Re: Planning Application 18/0993

Address: Pengarth 28 Dilworth Lane Longridge PR3 3ST

Description: Part two-storey, part single-storey rear and side extension to create grandparents annex, additional bedroom and extra living space. Resubmission of planning permission 3/2018/0214.

Proposed Site Layout

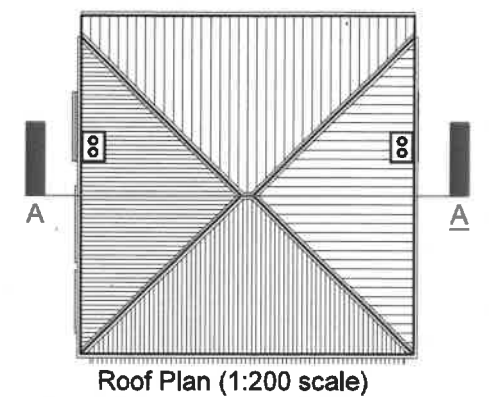
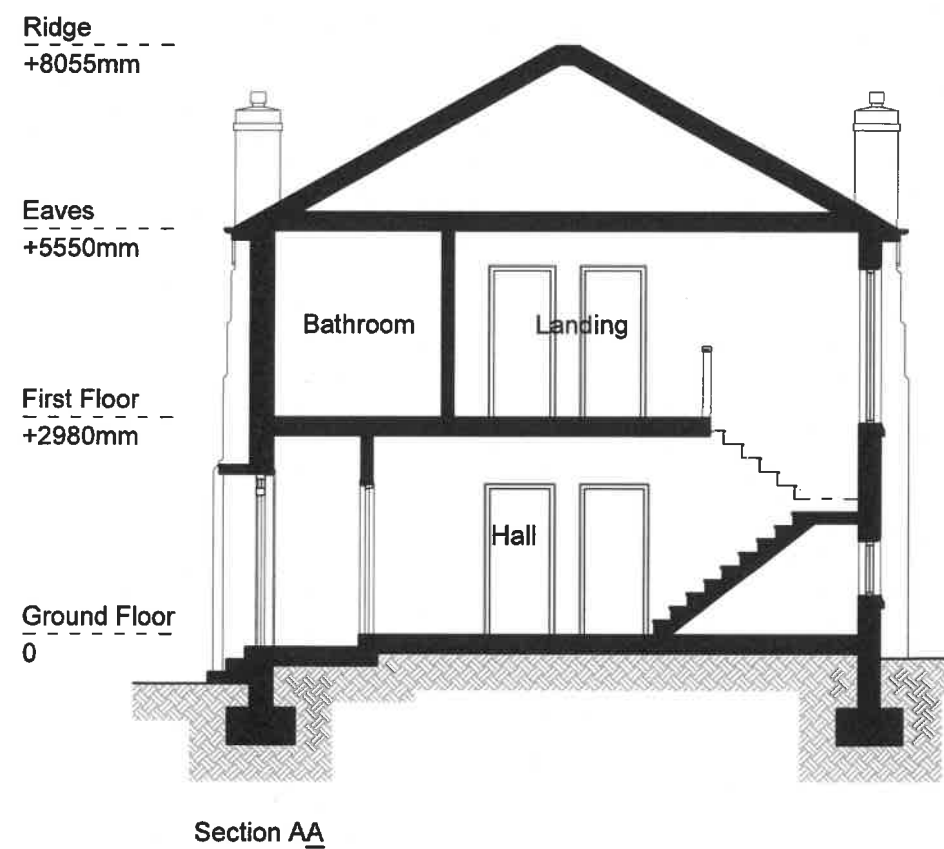
It is noted that the revised plan shows that the existing access is to be retained rather than altered, and as such would not then be subject to retrospective conditions regarding the visibility splay.

1. The layout of the development shall include provisions to enable vehicles to enter and leave the highway in forward gear and such provisions shall be laid out in accordance with the approved plan and the vehicular turning space shall be laid out and be available for use before any development commences and a suitable turning area is to be maintained thereafter. **Reasons:** Vehicles reversing to and from the highway are a hazard to other road users, for residents and construction vehicles.
